**Haweswater Aqueduct Resilience Programme, Bowland Section**

**Ecology Comments on Planning Application 3/2021/0660  
(Ribble Valley Borough Council)**

**John Jones  
Senior Ecologist  
Design & Construction Service  
Lancashire County Council**

**28<sup>th</sup> September 2021**

LCC\_RVBC-BO-FIG-009-02-03  
Figure 9B.3 Water Vole Baseline

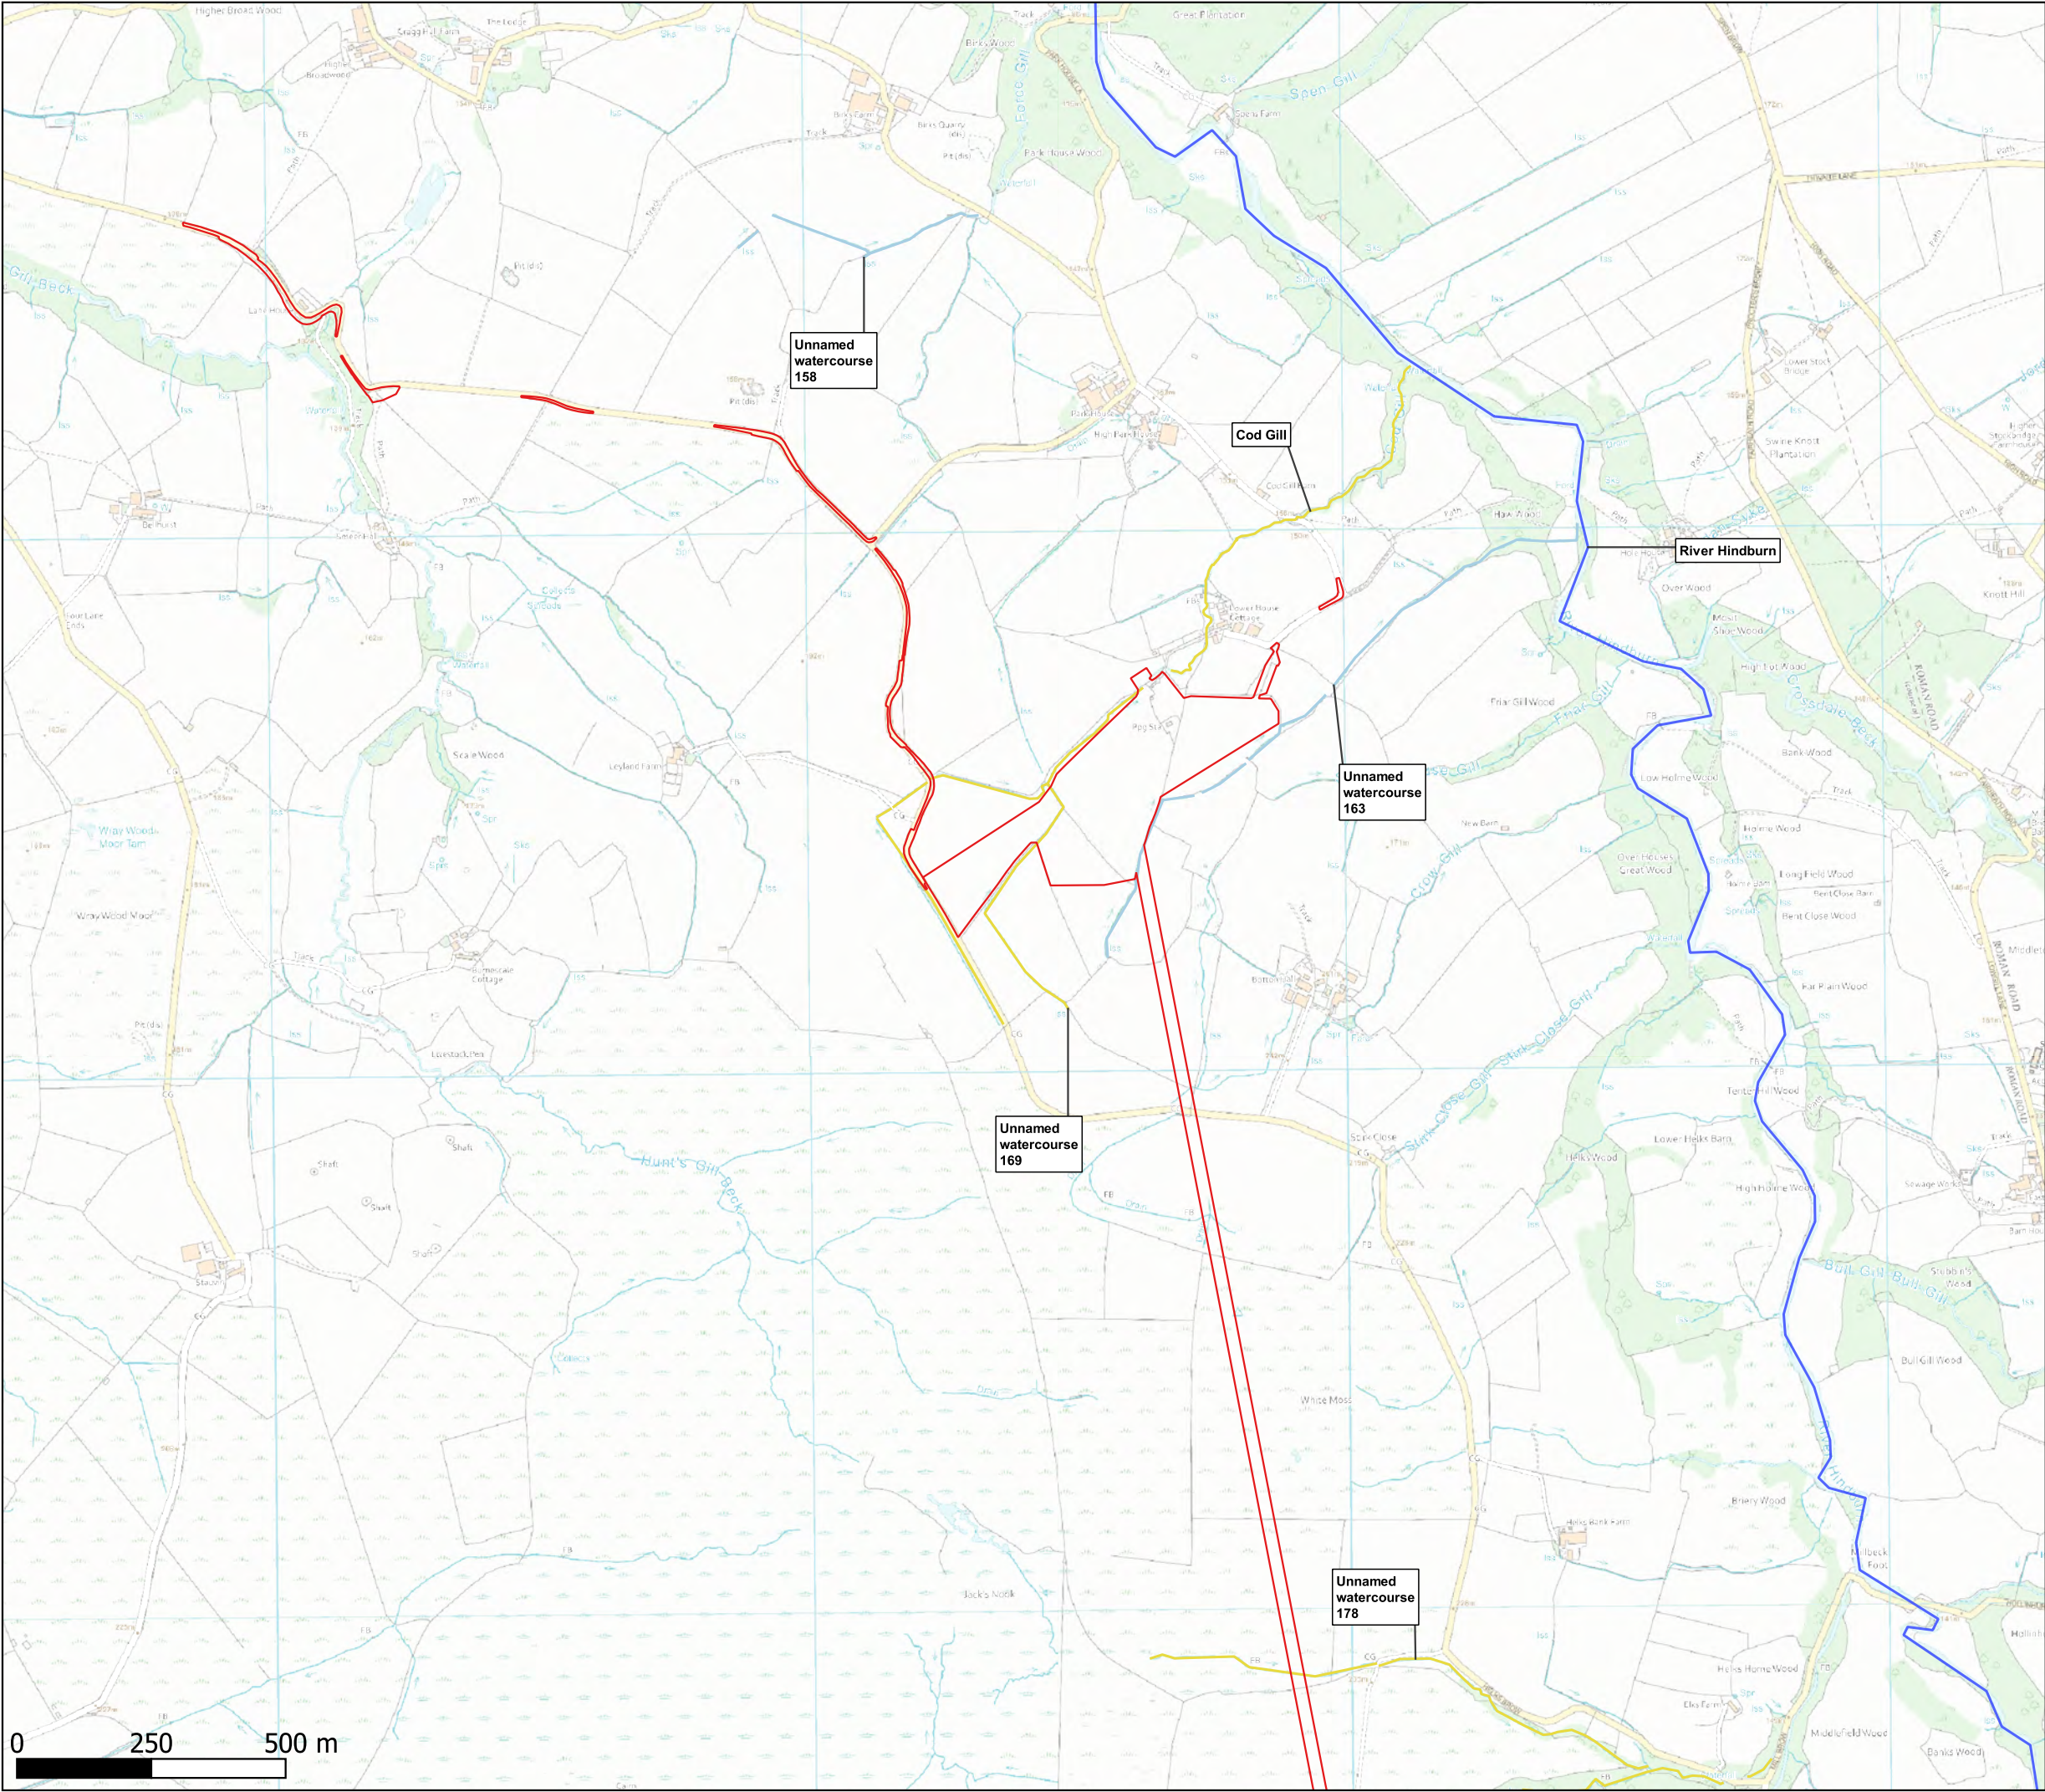
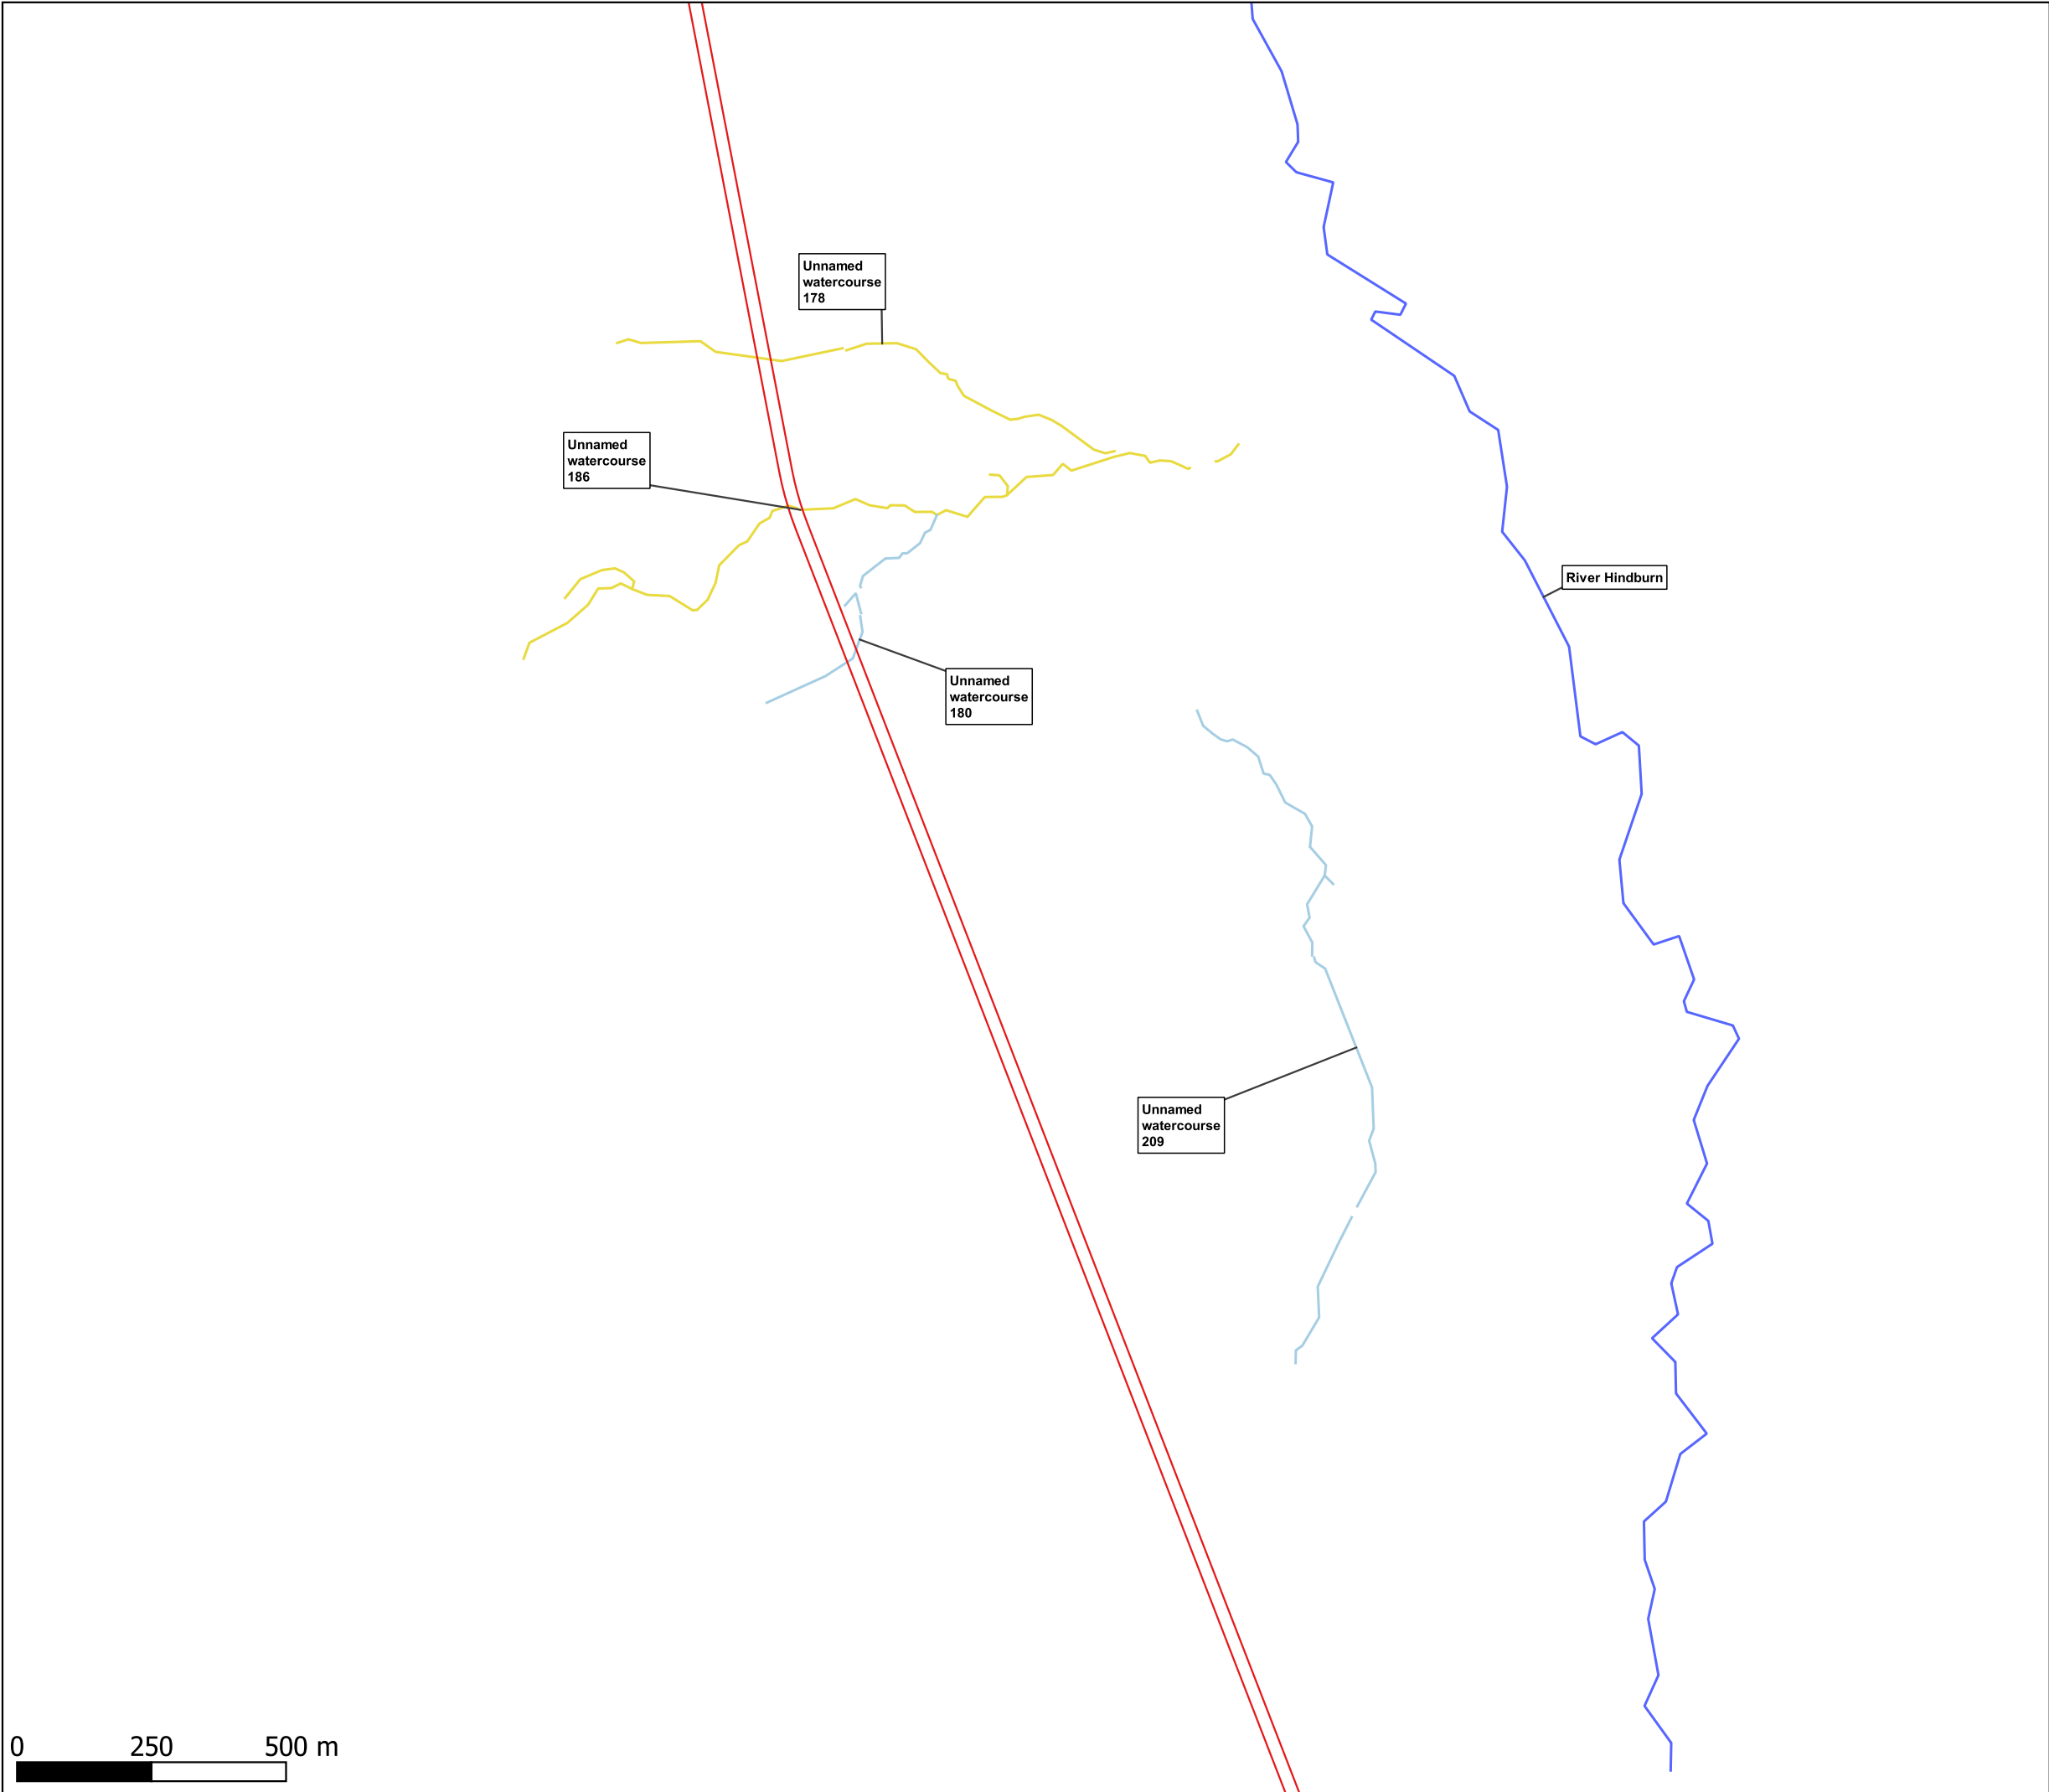
The Environmental Statement and water vole survey appendices appear to refer only to water vole surveys undertaken by Bowland ecology in 2019-20. These surveys did not identify the presence of water voles. However, the 2019 surveys were undertaken during suboptimal water course conditions following an exceptionally wet autumn and the surveys comprised one visit only, which does not meet recognised guidelines (see stated limitations within the Bowland Ecology report).

However, additional water vole survey results by RSK, undertaken in 2020 and 2021, have been included with the otter survey appendices. These results include evidence of water voles (including burrows and feeding signs) in locations that would be affected by the proposed development, including the Newton-in-Bowland compound and vicinity. These results and likely associated impacts do not appear to have been addressed within the relevant ES chapters. A licence from Natural England is likely to be required before works affecting water voles and their burrows could commence.

It is acknowledged within the RSK water vole report that not all surveys were undertaken during the appropriate survey season.

- All necessary water vole surveys need to be completed in accordance with recognised guidelines.
- The Environmental Statement needs to be updated to take into account the RSK water vole survey results and any further surveys.
